PLAN REVIEW SHEET

Petition #: RZP 2021-159

Address: 601 West Sugar Creek Rd.

Request: UR-2 (CD)

Drawing No. **RZ-1.0**

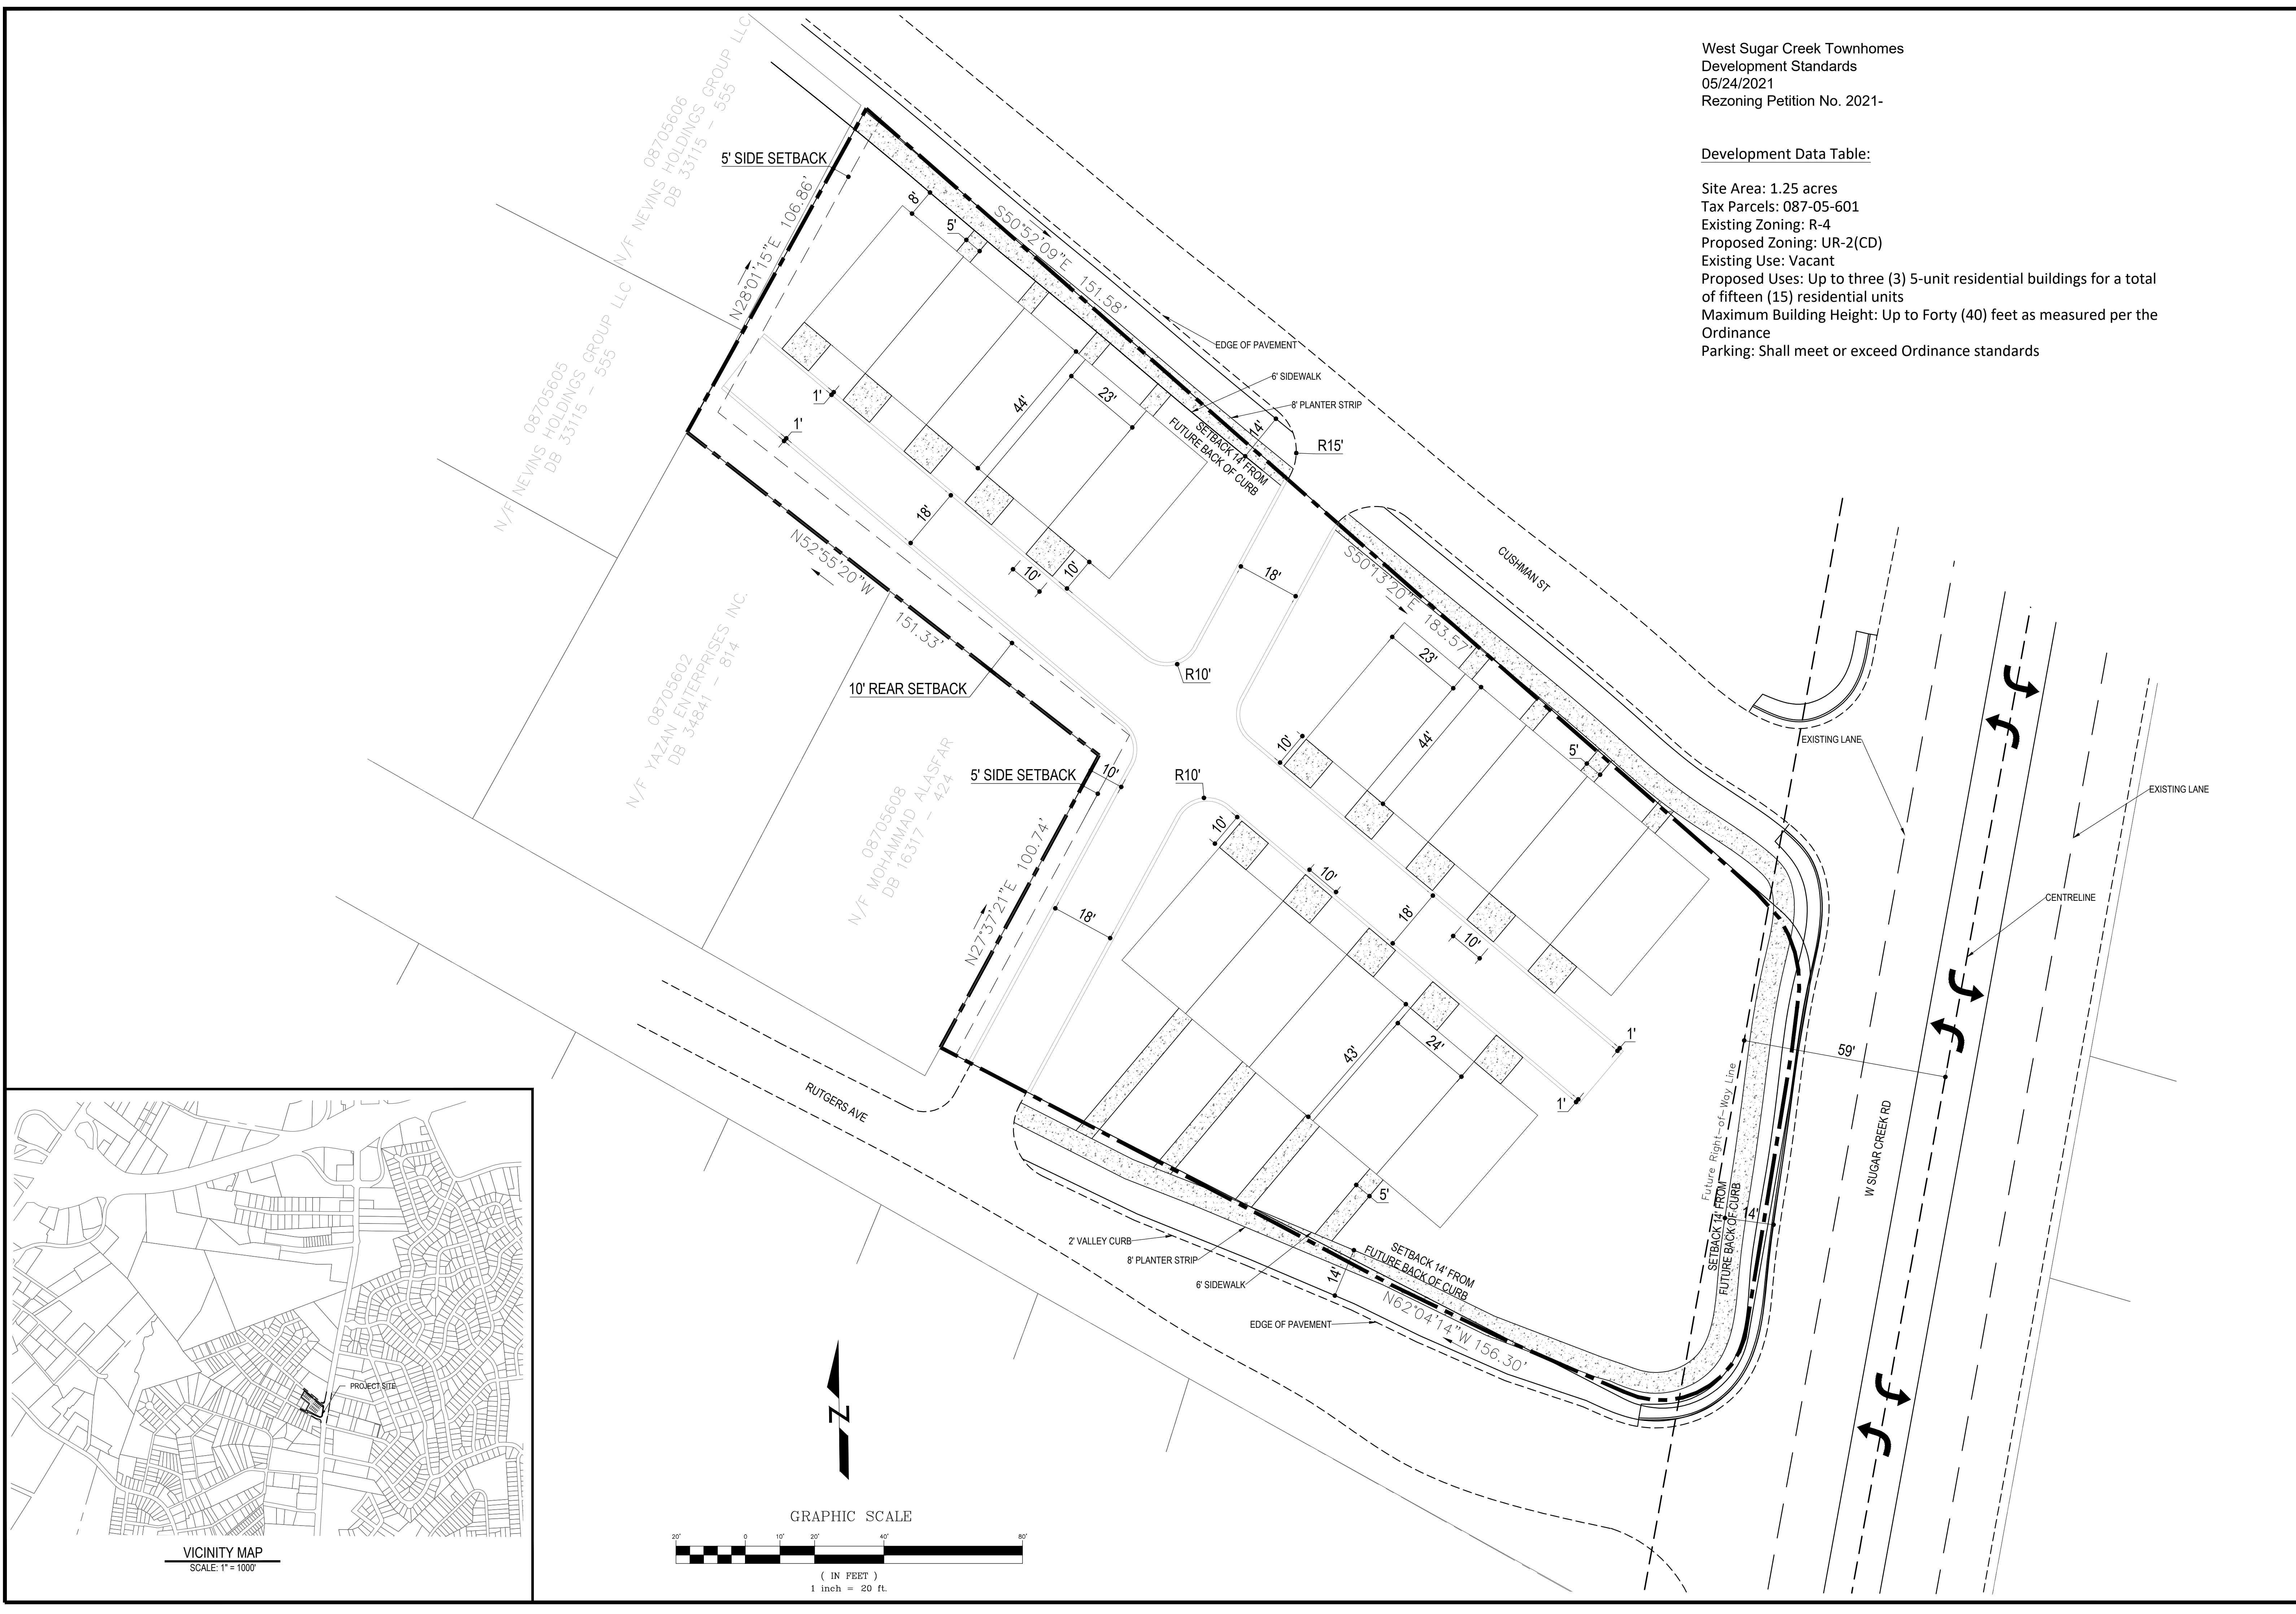
The site is located along CATS local bus route #211 on West Sugar Creek Rd. CATS requests the construction of a bus shelter pad and ADA compliant waiting pad per Land Development Standard 60.03A along West Sugar Creek Rd. The final location of the pads will be coordinated with the developer through the permitting process.
